DRB Application No.: 04DRB-01300 (P&F)

Project Name: MESA VERDE ADDITION

**CITY OF ALBUQUERQUE
PLANNING DEPARTMENT
September 1, 2004
DRB Comments**

RE: Lots 46 & 47/ Mesa Verde Addition/minor plat

PLAT OF
 LOT 47-A, BLOCK 4
MESA VERDE ADDITION
 A REPLAT OF LOTS 46 AND 47, BLOCK 4
 MESA VERDE ADDITION
 WITHIN SE 1/4, SECTION 19, T.10N., R.4E., N.M.P.M.
 ALBUQUERQUE, BERNALILLO COUNTY, NEW MEXICO

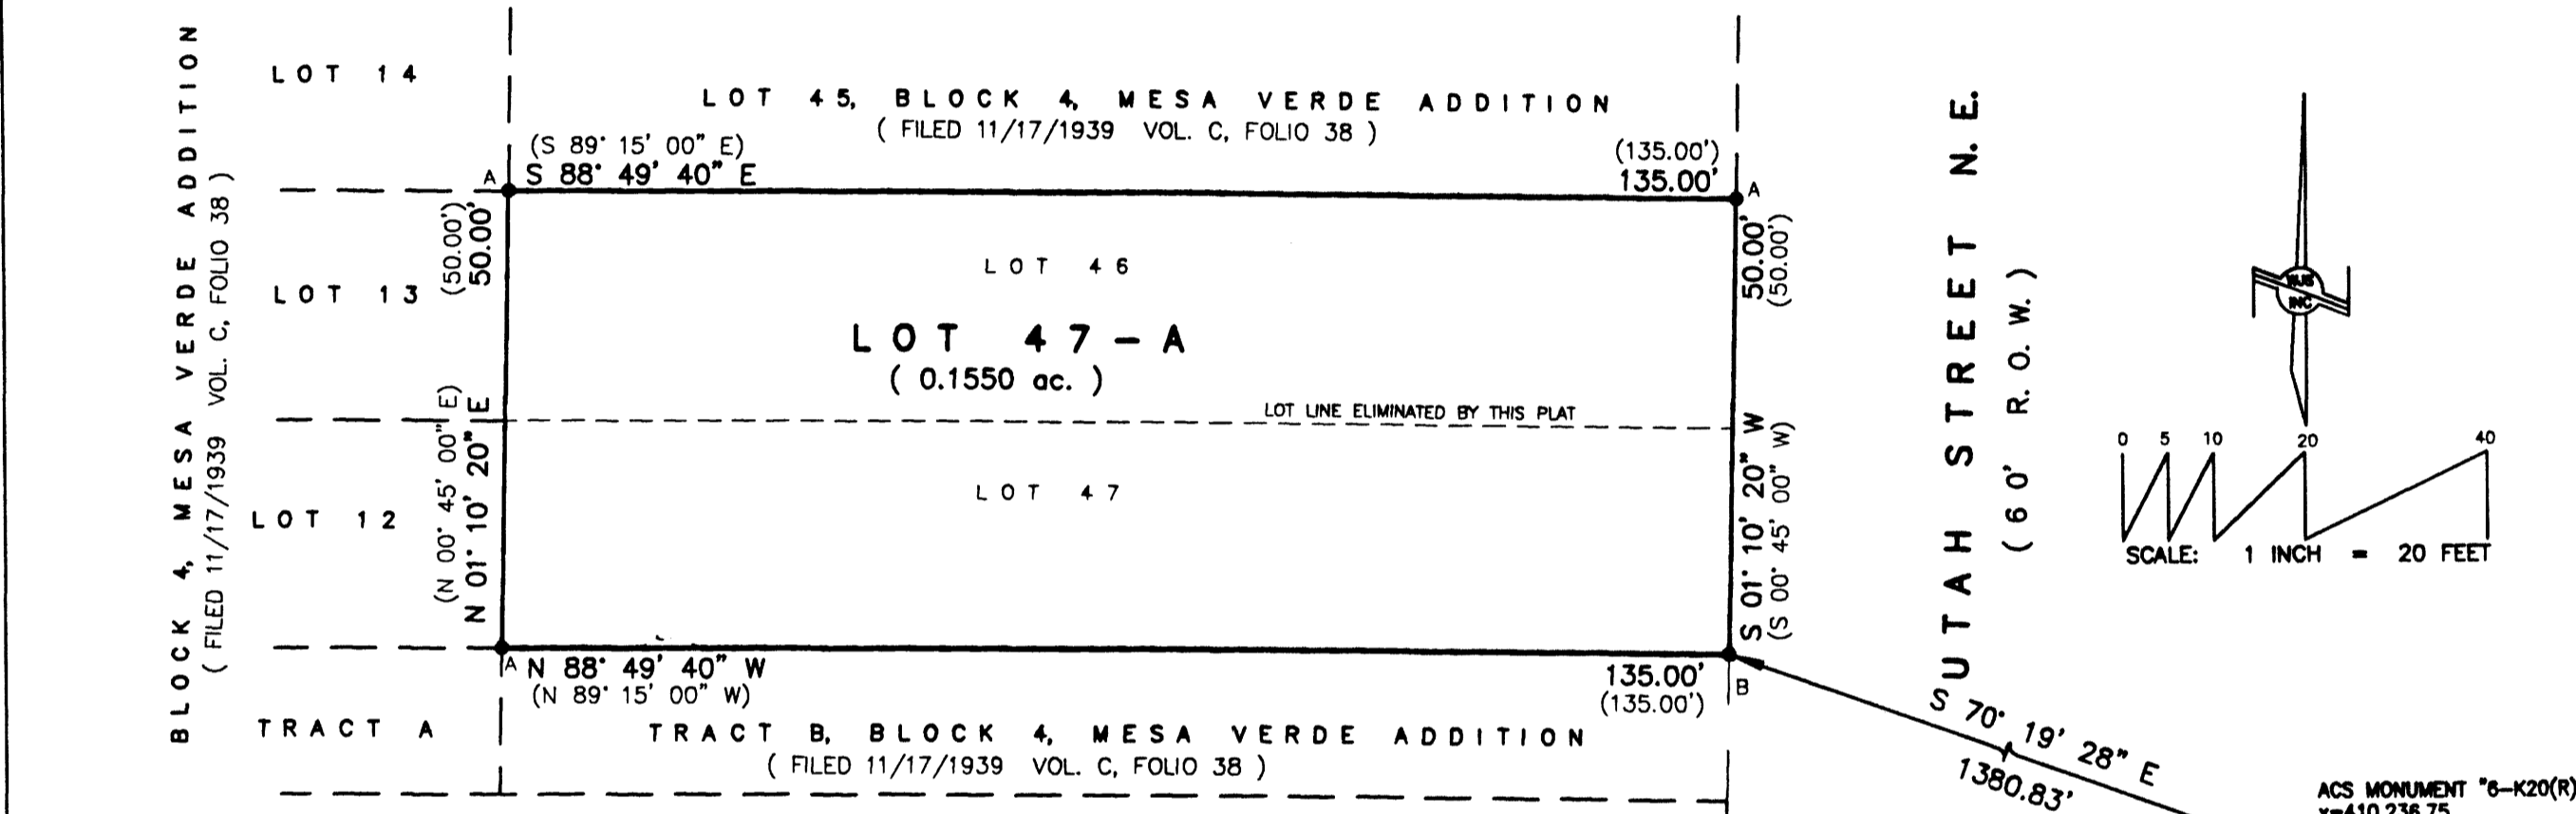
Planning has no objection to the replat assuming the new addition to the rear building will leave at least a 5 foot setback from the property line closest to Utah and the front building is the one planned for demolition.
